13 September 2018

HONEYSUCKLE DRIVE (LOCAL ROAD): SSD 8999, TWO EIGHT-STOREY MIXED USE BUILDINGS AND ONE SINGLE-STOREY RETAIL BUILDING CONTAINING GROUND FLOOR RETAIL PREMISES, 92 RESIDENTIAL APARTMENTS, TWO BASEMENT LEVELS OF PARKING CONTAINING 190 SPACES, PT LOT: 2000 DP: 1145678, 35 HONEYSUCKLE DRIVE, NEWCASTLE

Reference is made to Department of Planning and Environment's ('DPE') letter dated 20 August 2018, regarding the abovementioned application which was referred to Roads and Maritime Services (Roads and Maritime) for comment. Apologies for the delayed response.

Drawing Name
Floor Plan - Basement 02

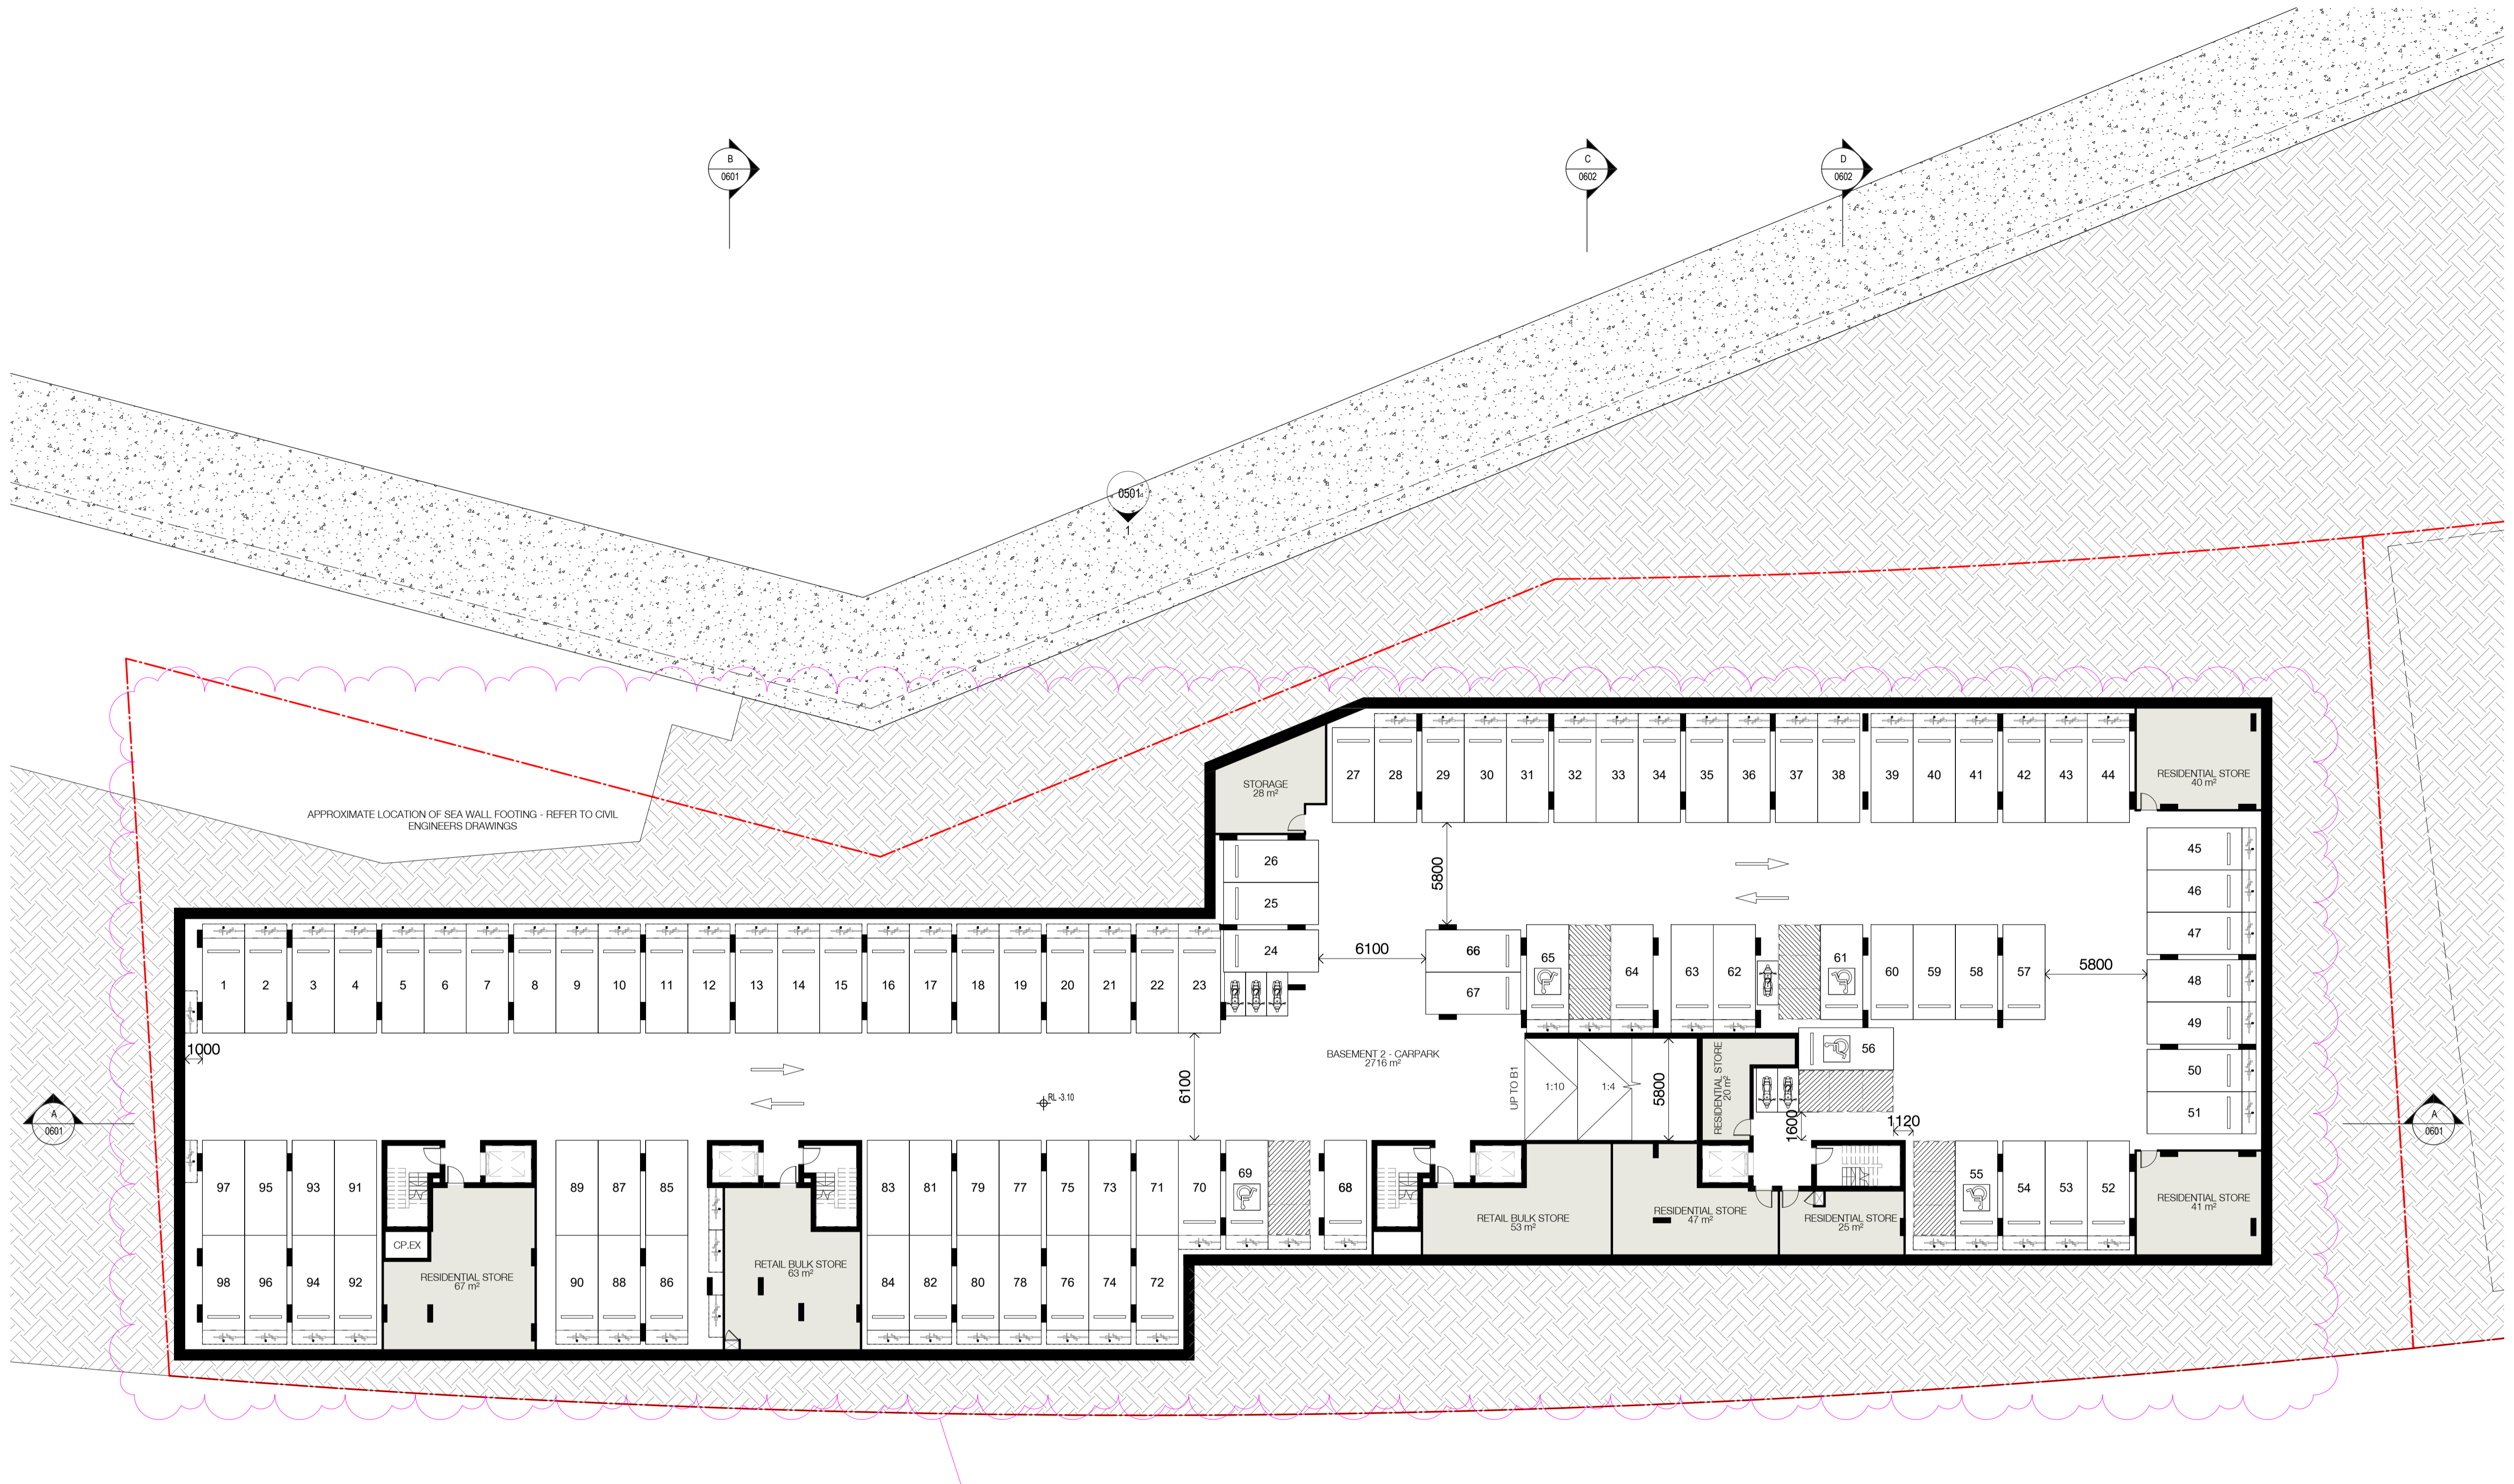
Honeysuckle Drive is a collector road and will experience heavy traffic volumes in peak hours. The proposed direct access from Honeysuckle Drive is therefore undesirable for all road users (including pedestrians) particularly when the opportunity exists for the provision of a signalised side access road which can improve management of traffic flows and the overall efficiency of the road network.

As raised in Roads and Maritime's previous correspondence dated 10 January 2018 in response to the SEARs request Roads and Maritime identified the potential for the planned traffic controls signals ('TCS') at Honeysuckle Drive and Steel Street to be upgraded to provide a fourth (north) leg. The signalised T-

intersection has now been completed and Roads and Maritime recommends that the additional leg be constructed by the developer to accommodate left-in / left-out and through movements for future occupants of the development to both the northeast (subject site) and northwest of the intersection. Accordingly, it is recommended that DPE consider the proposed design be amended to include access from a northern leg to promote efficient and safe travel for all road users and future occupants of the site.

- Council should have consideration for appropriate sight line distances in accordance with the relevant Australian Standards (i.e. AS2890:1:2004) and should be satisfied that the location of the proposed driveway promotes safe vehicle movements.

Note, should a fourth leg extension from the existing Steel Street traffic control signals be sought as part of this proposal, detailed designs should be submitted for Roads and Maritime's consideration prior to the issue of any consent.
